Consultation Response from KC, Conservation & Design
2026/90657 6, Nelson Street, Dewsbury, WF13 1NA
Listed Building Consent for replacement of specified external doors and windows with like-for-like units (within a Conservation Area)
Date Responded: 1/5/26 Responding Officer: SC Responding Ref:

This response is in respect of both applications 2026/90656 and 2026/90657.

This building is Grade II listed and within the Conservation Area.

Door Elevations [1:20]

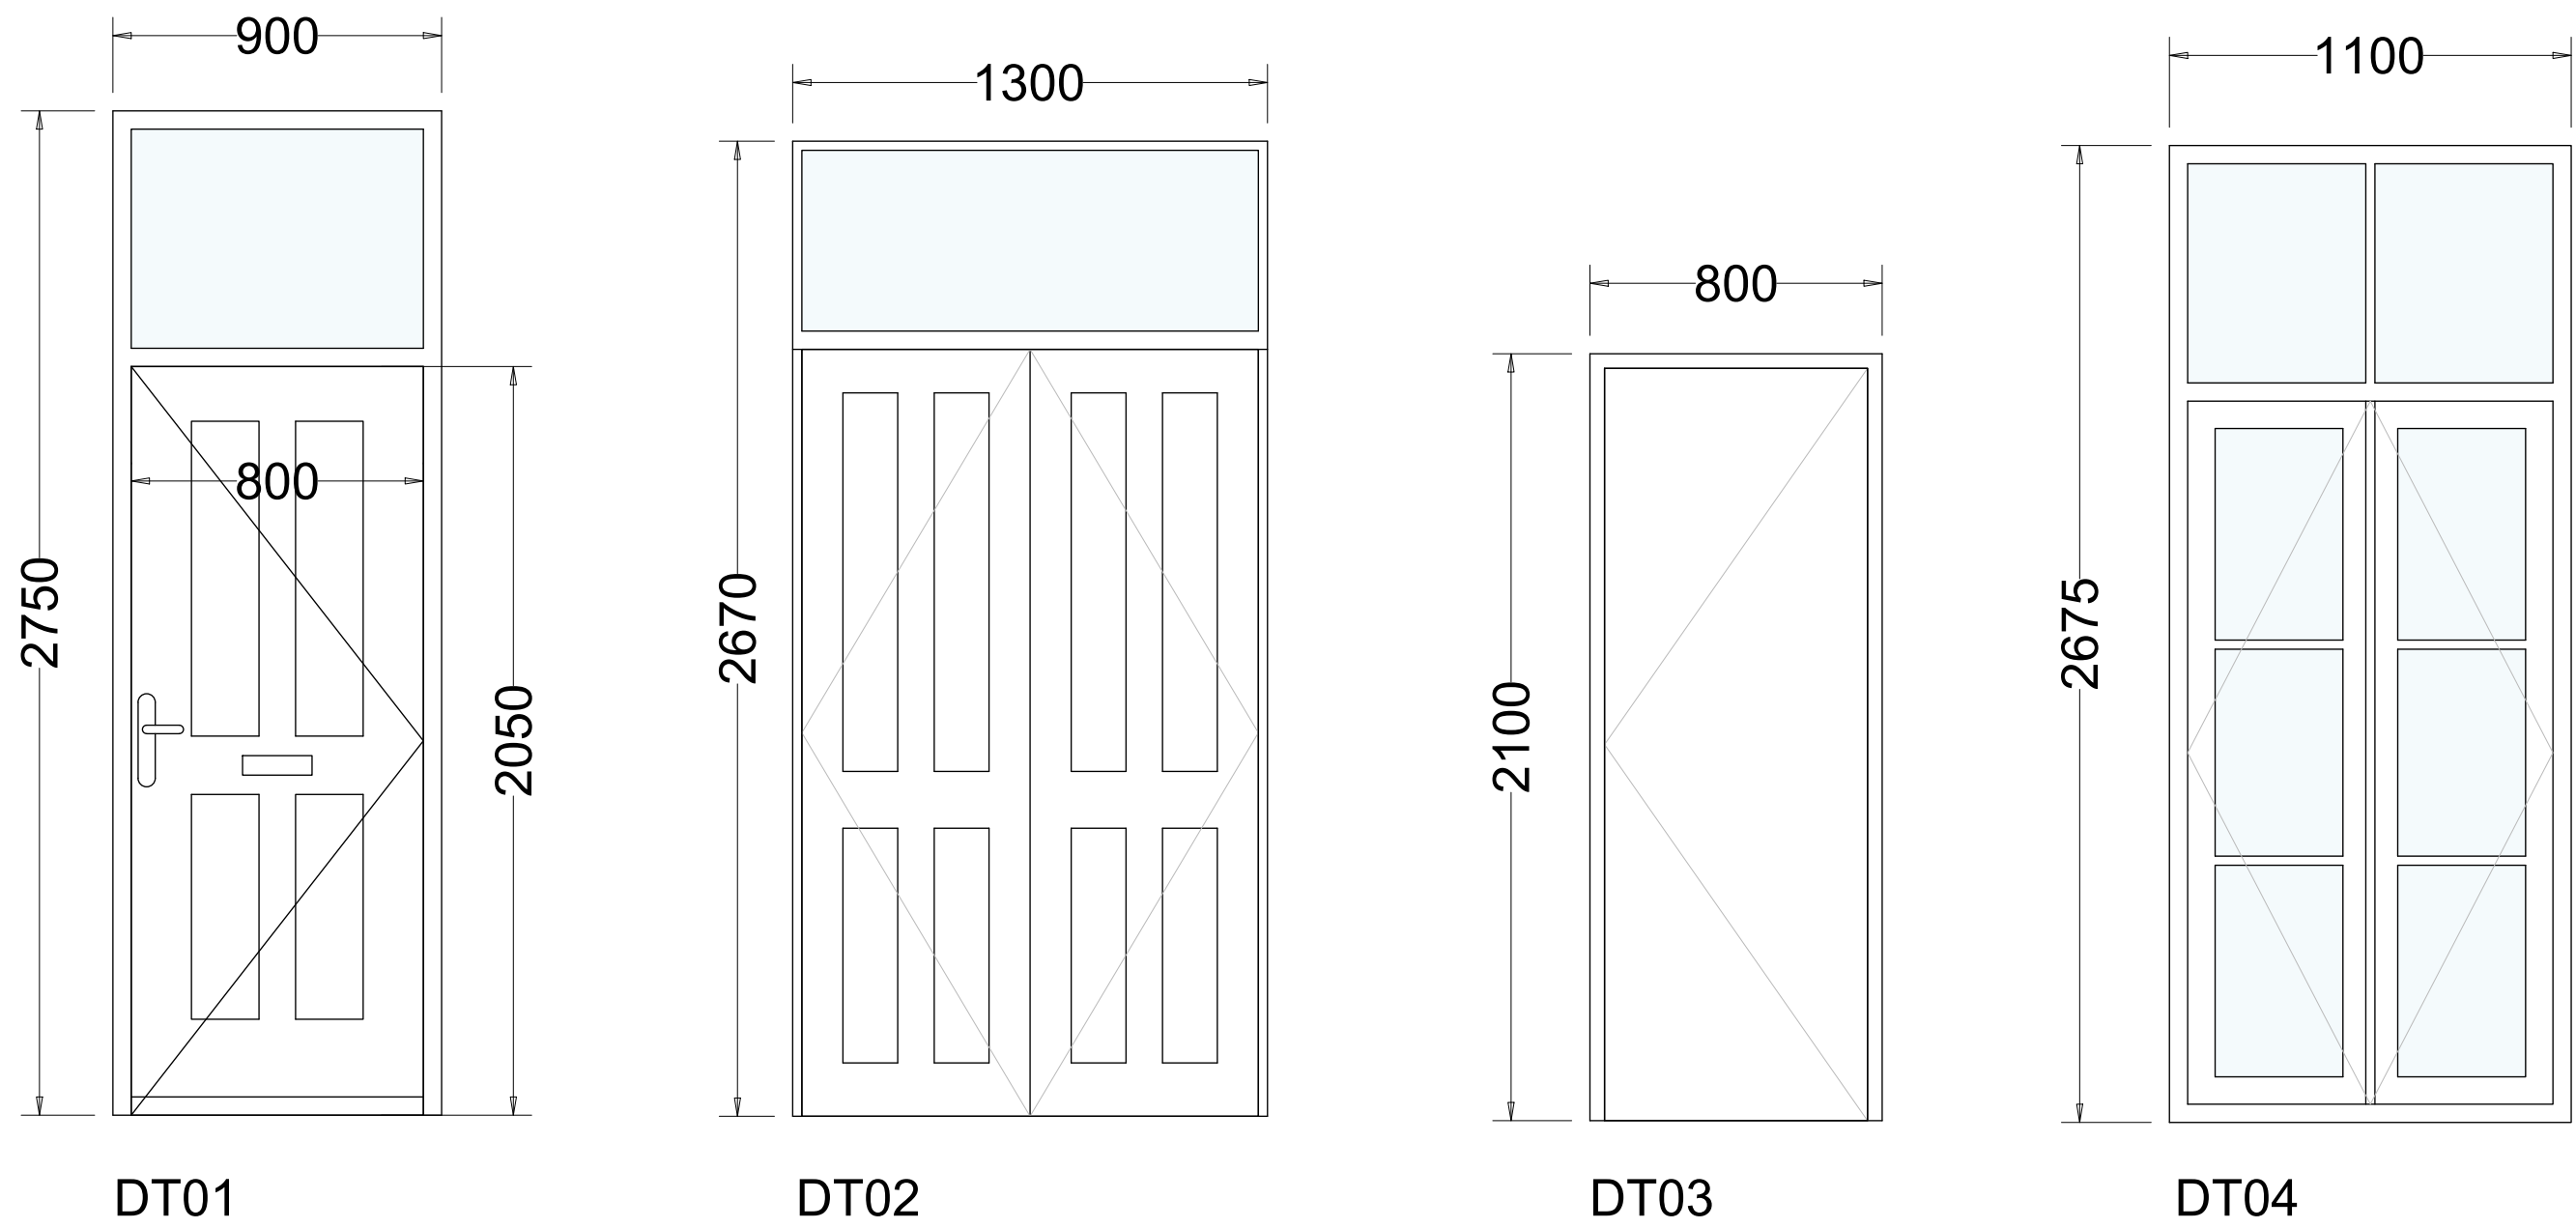
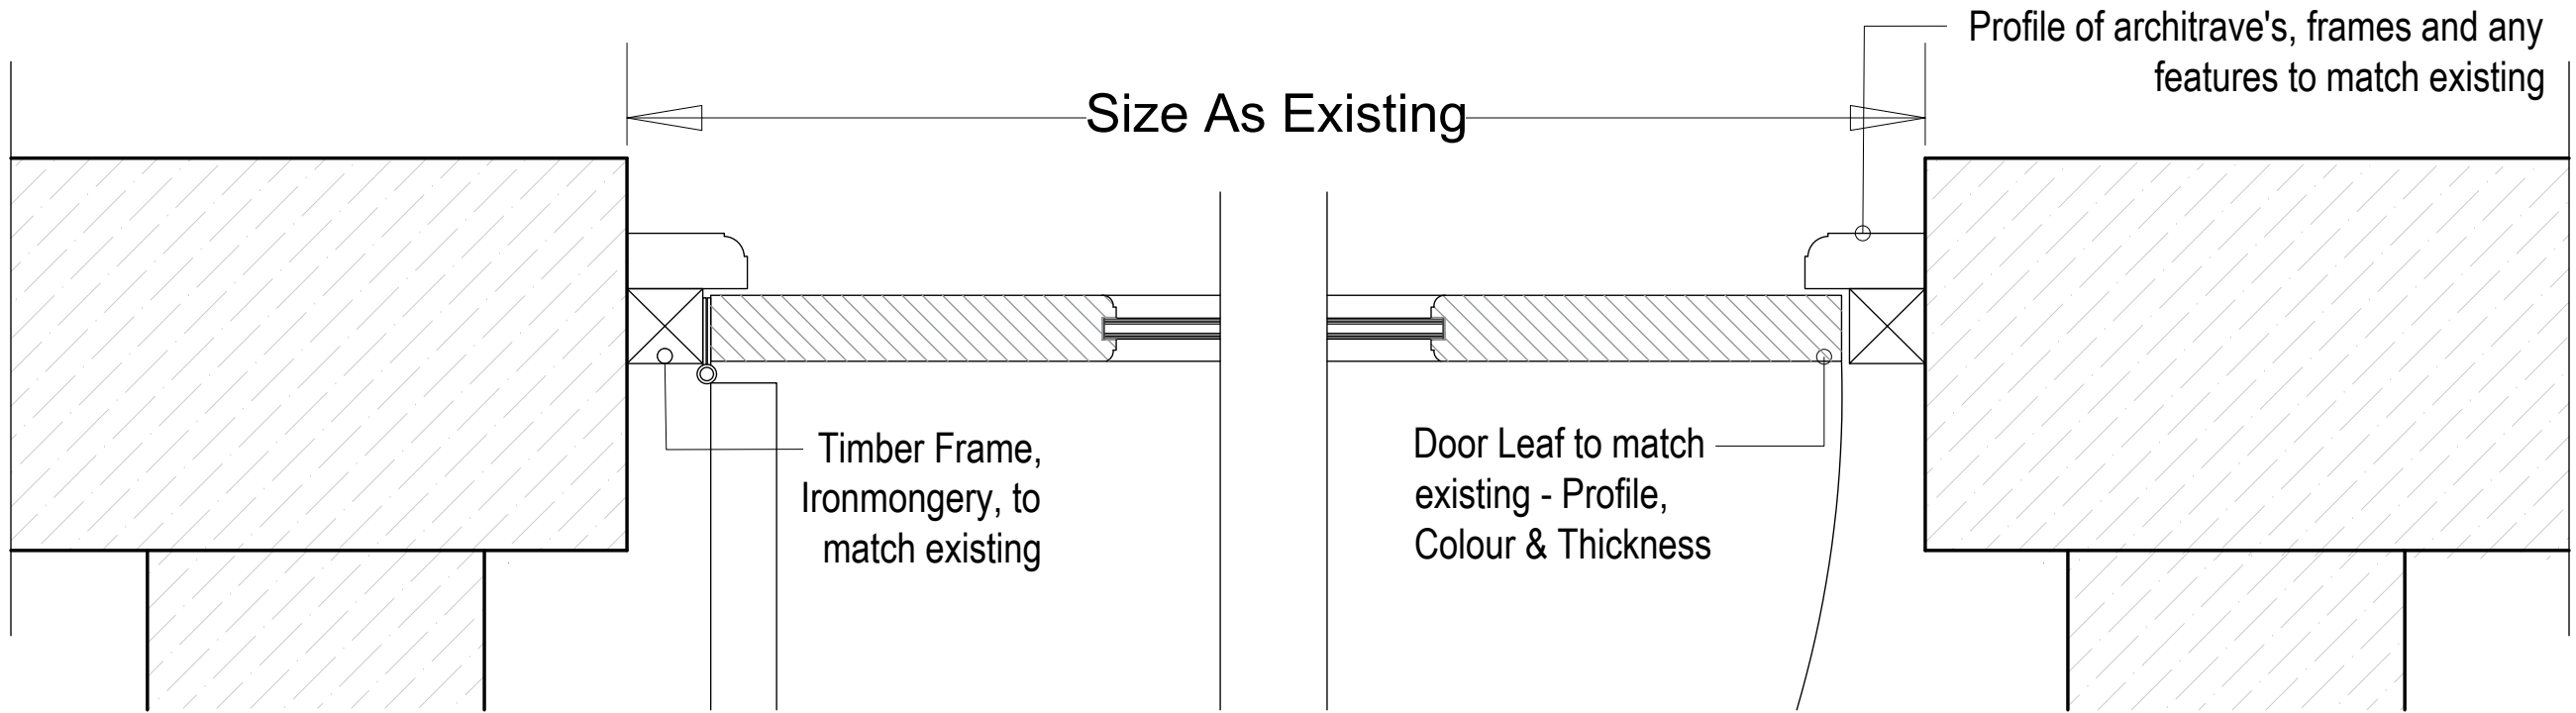
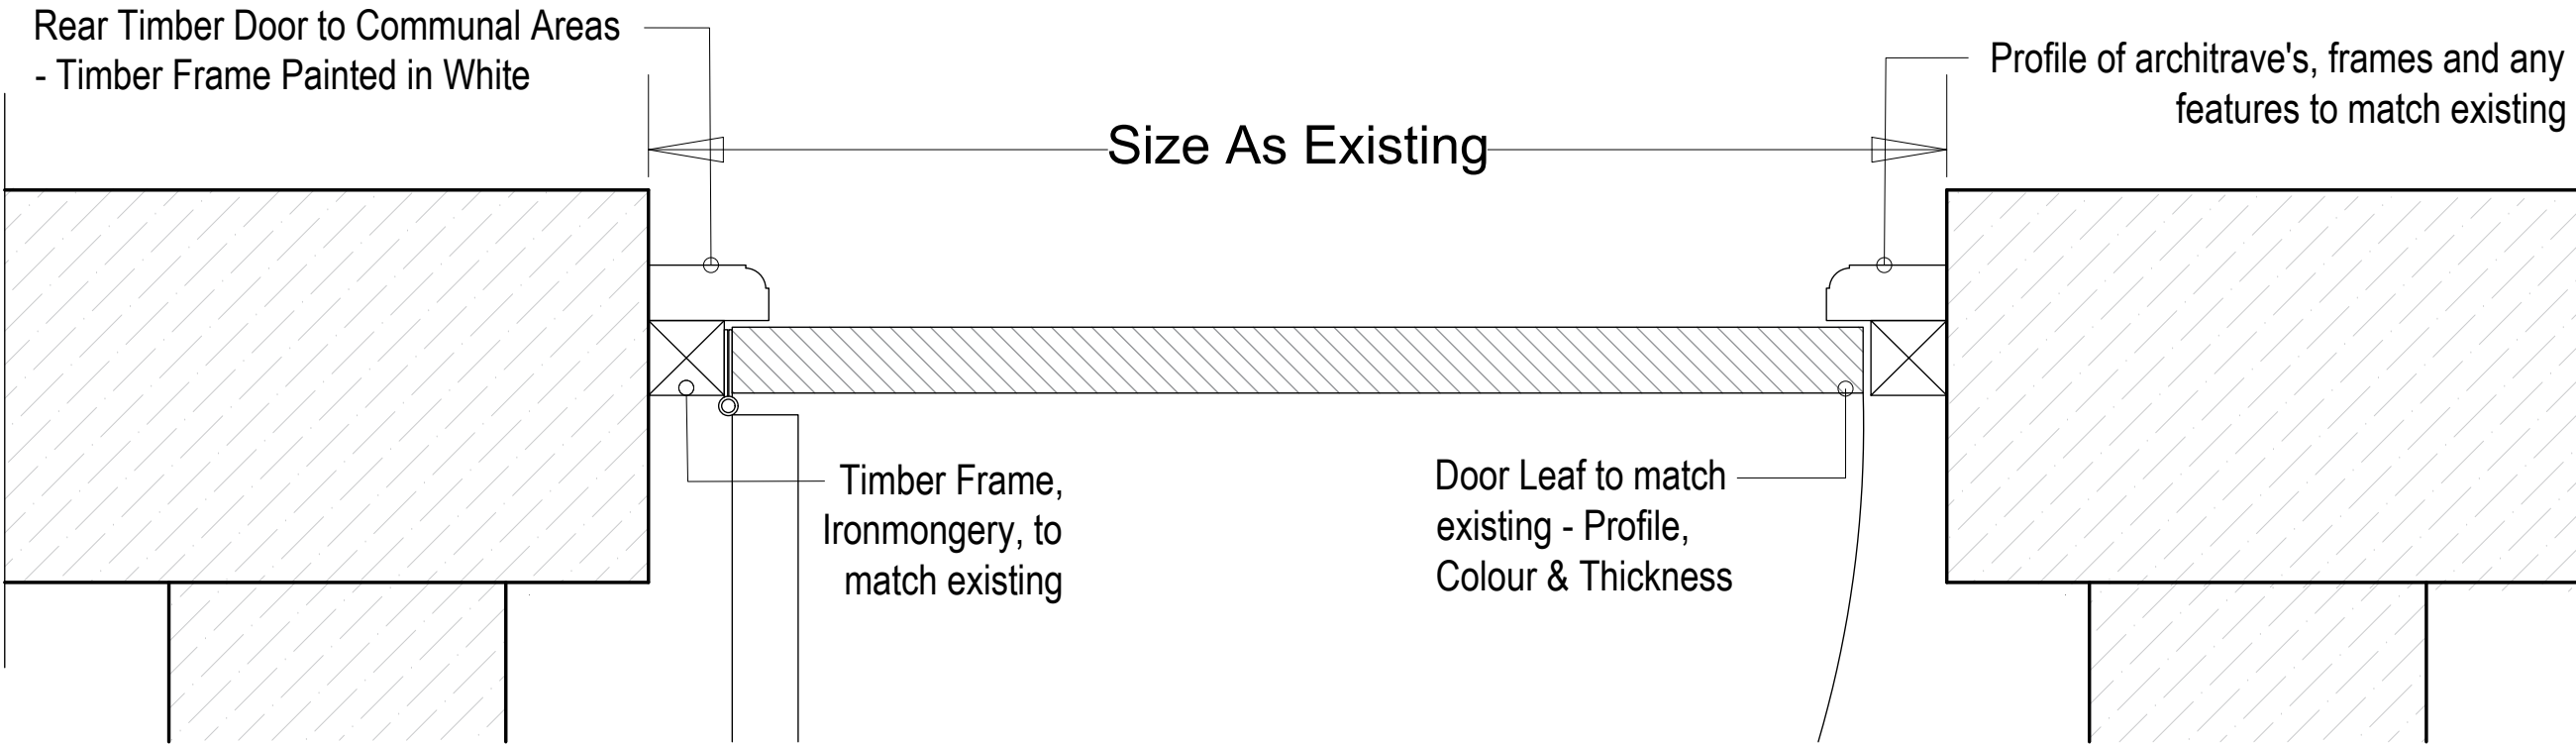
The doors are proposed to match existing but must be in timber (the Design and Access statement indicates high-quality hardwood units to be used) not composite.

2. All external doors shall be constructed of timber (not composite) to match existing, with no visible tricklevents, and the frames shall be set back in the reveal with 75-100mm or to match existing and shall not be fitted flush with the external wall.
3. All external joinery shall have a painted finish in off-white, or to match existing or in accordance with a colour scheme to be submitted to and approved in writing by the Local Planning Authority before painting works commence. The works shall then be carried out in complete accordance with the approved details and shall be retained thereafter.

Existing & Proposed Window Elevations

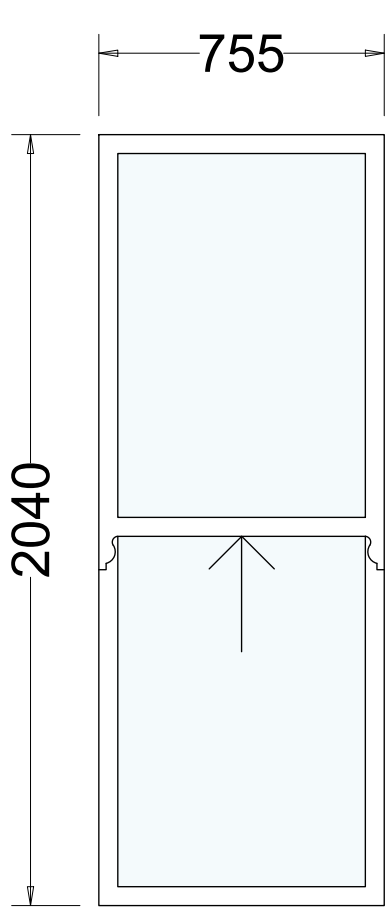
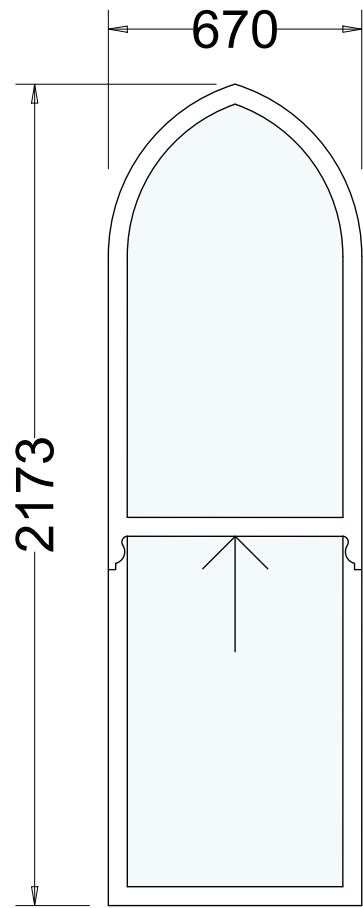
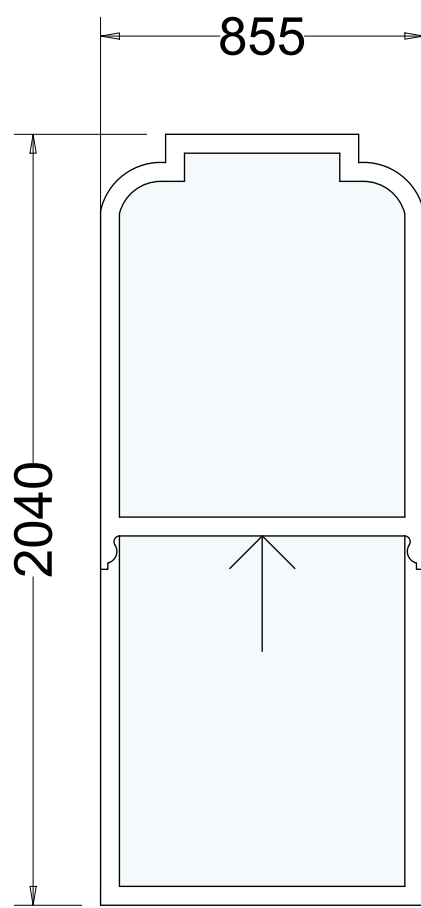
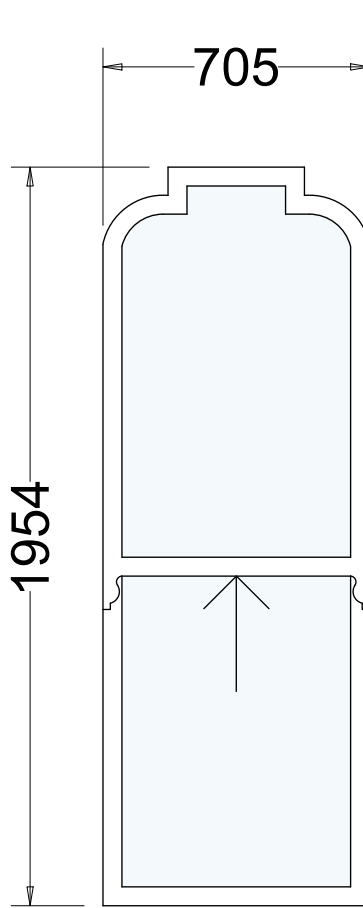
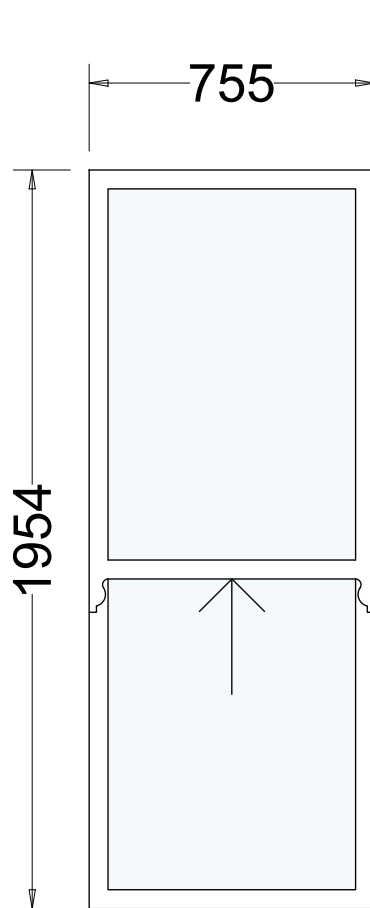
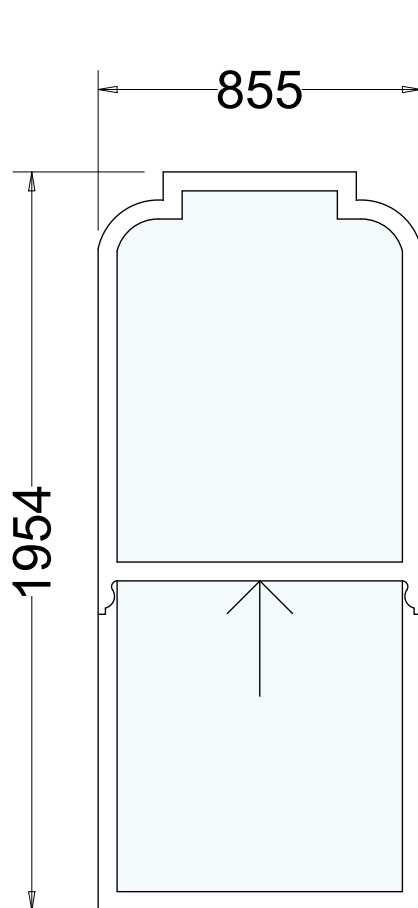
The existing doors are not original and it is unlikely that the windows are original, although they are single glazed currently. The existing windows respect the intricate arched stone window frames. It appears that the upper windows currently might be fixed, with the lower pane moving up and down for ventilation with internal fall-prevention barriers.

The submitted details indicate that windows and doors will be replaced with timber to match existing. Composite has been mentioned on the application form, but that is not acceptable.

The new windows must replicate the existing as closely as possible by replicating the horn detail and mould profiles, frame depth, and set-back within the reveal, with traditional putty-faced glazing.

1. Notwithstanding the details provided, all windows shall match the existing joinery details in terms of material, profiles, detailing, dimensions, albeit with an increase in the internal section sufficient to accommodate slim double glazing. All slim double-glazed units shall have a maximum of 4mm glass with an 8mm gap with black spacer bars.

New opening windows shall be sliding sashes. Visible trickle vents shall not be permitted. All new window frames shall be set back in the reveal by 75-100mm or to match existing and shall not be fitted flush with the external wall.
